CITY OF PORTLAND, MAINE
HISTORIC PRESERVATION BOARD

April 22, 2015

Re: Proposed Rooftop Dormer Additions

EXTERIOR ELEVATIONS
 & ROOM FINISH
 SCHEDULE
A2.1

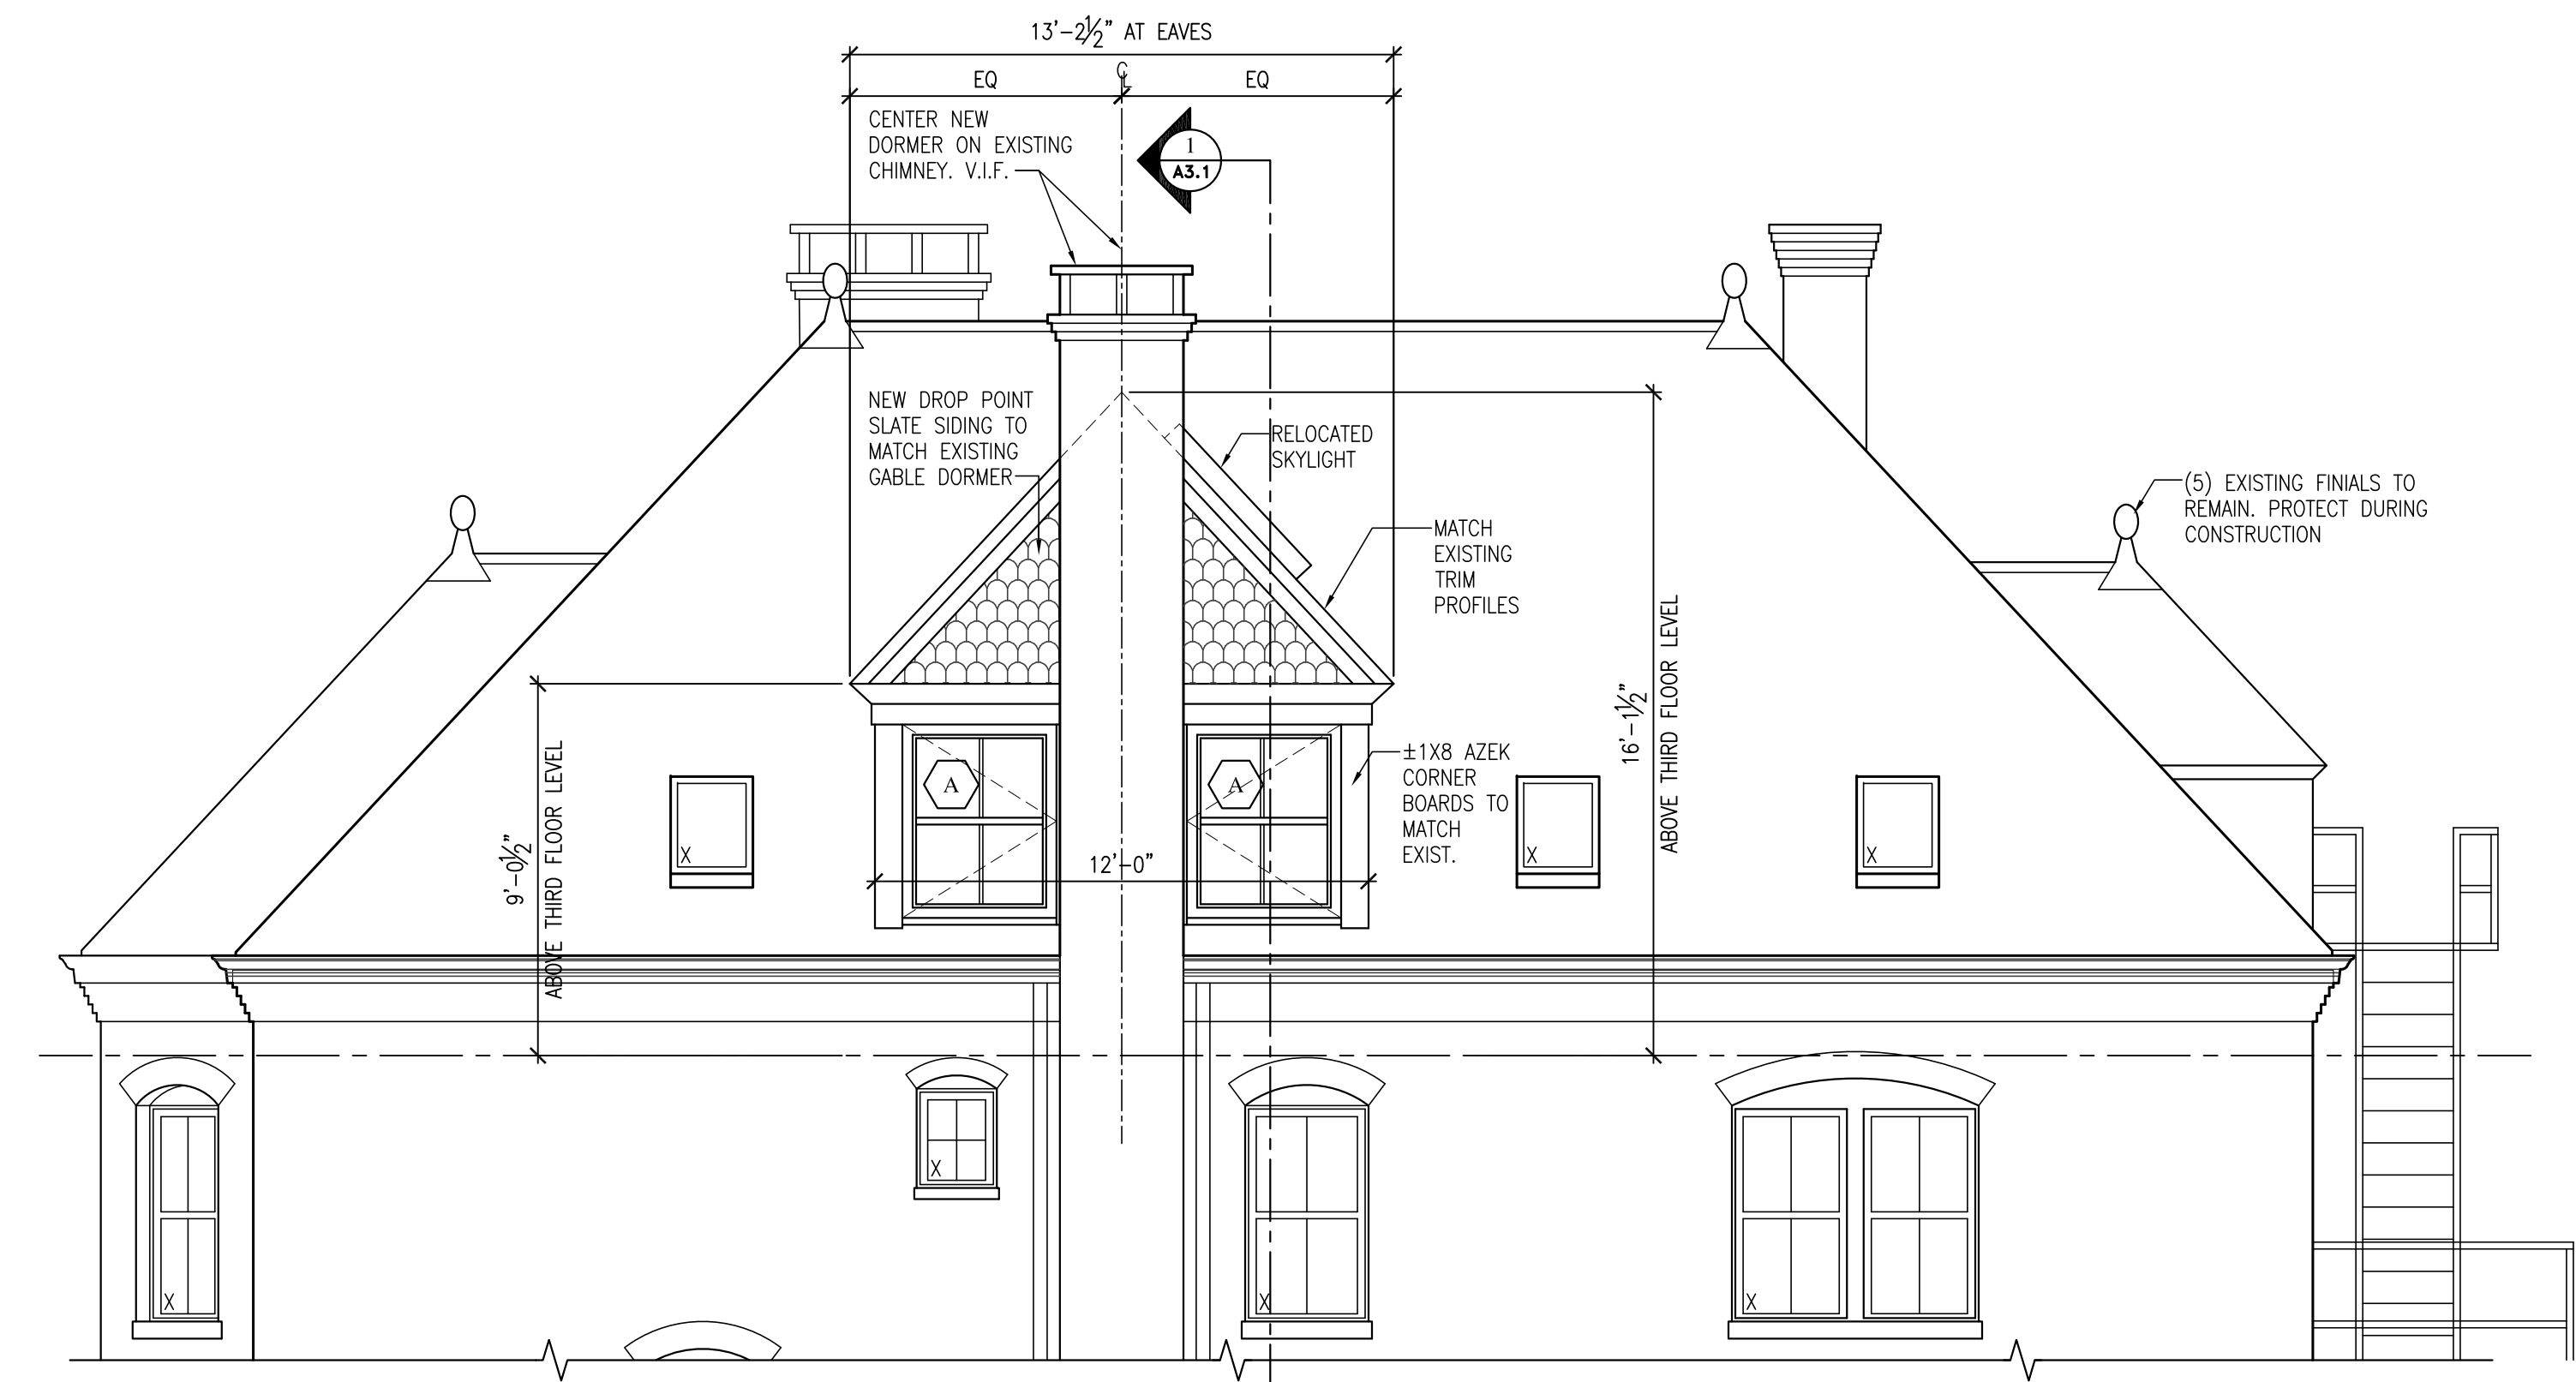
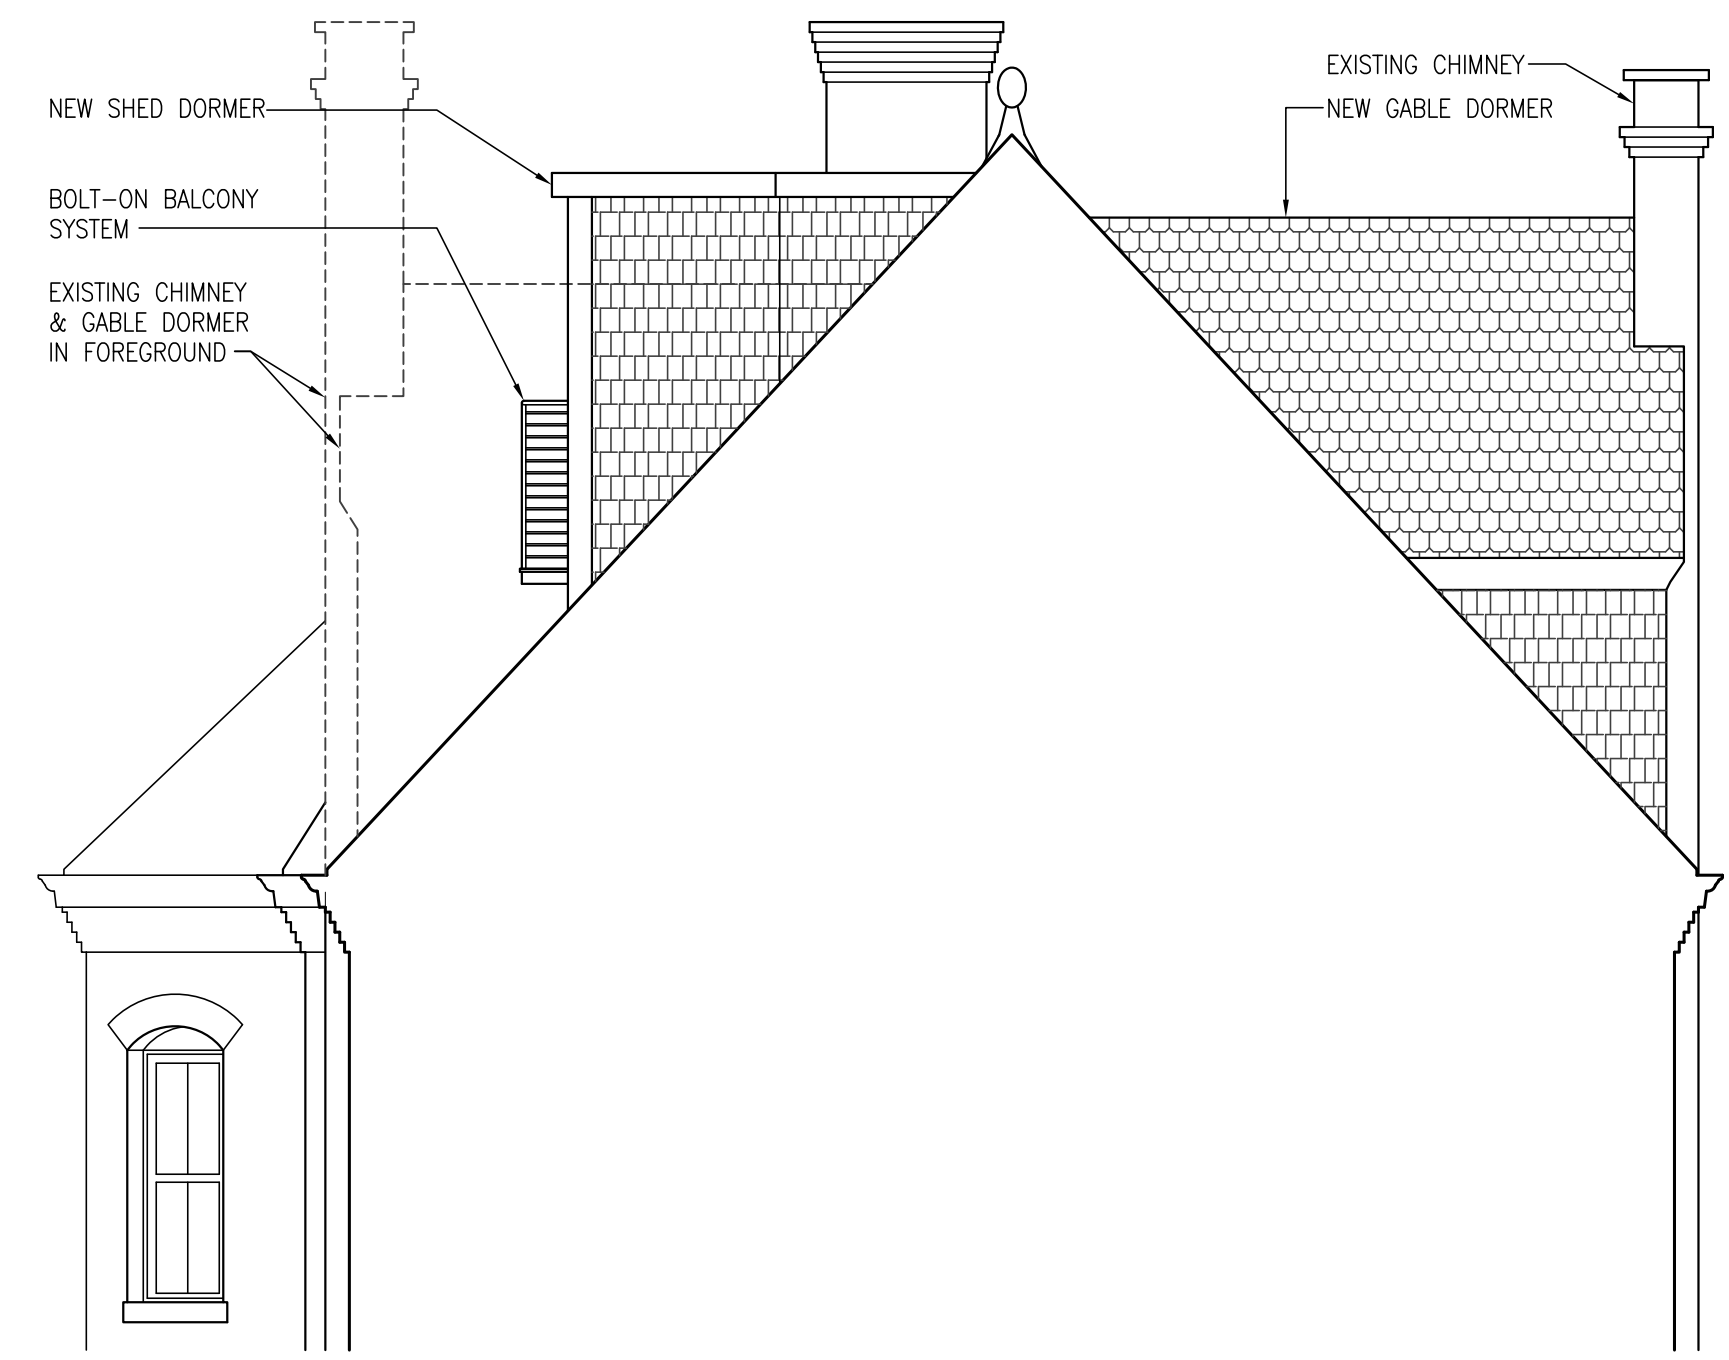
- Every effort shall be made to lower the roof of the south dormer to minimize its visibility, and if possible, render it completely invisible as viewed from the street. HP Board recommends revising the roof to be flat, with a lowered ceiling height and engineered roof framing, to lower the profile as much as possible. Final design is to be reviewed and approved by HP staff.
- The maximum size of the south balcony is to be 1' deep by 7' wide. Balcony doors are to swing in.
- The final specifications and color of the casement windows in the proposed north dormer are to be submitted to staff for review and approval. Windows are to be articulated, with SDL muntins and false meeting rail to convincingly mimic double-hung windows.
